Re: Bass Point Quarry (PA 08_0143 Mod 3) – Request for Information

The following presents a response to matters raised in the Department's Request for Information letter dated 28 June 2022 in relation to the proposed Modification 3 to Project Approval 08_0143 to:

Figure 3 | Existing and proposed amenity barriers

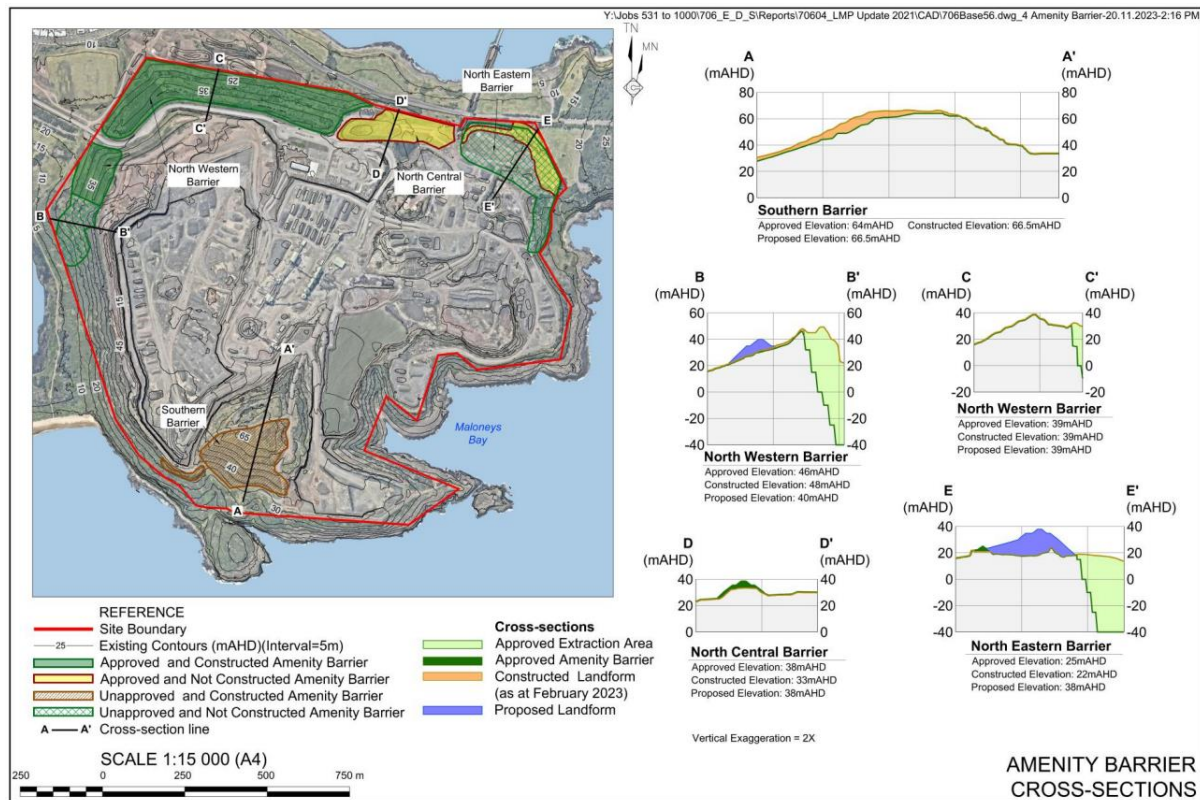
1. *Regarding the unapproved southern amenity barrier both areas under rehabilitation and areas to be constructed:*
 - a) *It is unclear from the information provided what function/utility this structure provides in relation to reducing noise and visual impacts of quarrying operations. Please justify and quantify the purpose of the structure in reducing the visual and noise impacts created by quarry operations.*

- c) *It is unclear how the material (existing and proposed) within the barrier would be incorporated into the progressive rehabilitation of the quarry. The proposed modification includes the importation of material to assist the rehabilitation of the final landform. However, the figures provided to date only show the creation of a large emplacement/barrier.*

The function and utility of the visual amenity barriers in relation to visual and noise impacts relate to the physical interruption of possible views towards the Quarry and noise propagation from operating equipment within the Quarry. It is noted that the Bass Point Quarry Project was approved on the basis

of the existing layout and therefore the changes to the impact upon surrounding visual amenity and the possible noise generated by the current operations are considered acceptable. However, the addition of material to the existing southern barrier and the proposed extension to the east would provide additional mitigation. In addition, the views towards the Quarry from the south would benefit from a more irregular pattern in the landscape that may improve the outlook for some people. It is acknowledged that the change to the landscape and the mitigation of possible impacts would be minor compared to current mitigations that are applied at the Quarry. However, it is considered that there would be genuine benefits as a result of the process.

The material that would be used to construct visual amenity barriers would not be re-used for rehabilitation of the Quarry. The material imported to the Quarry Site would either be applied to land in visual amenity barriers or would be applied in rehabilitation activities within the Quarry Site. The Landscape Management Plan for the Quarry includes an indicative final landform plan which includes a large waterbody surrounded by and partially split by areas of native vegetation (see **Figure A**). The material imported to the Quarry Site for use in rehabilitation would be applied as subsoil or a growth medium (should it be suitable for this purpose). The material would supplement existing stockpiles
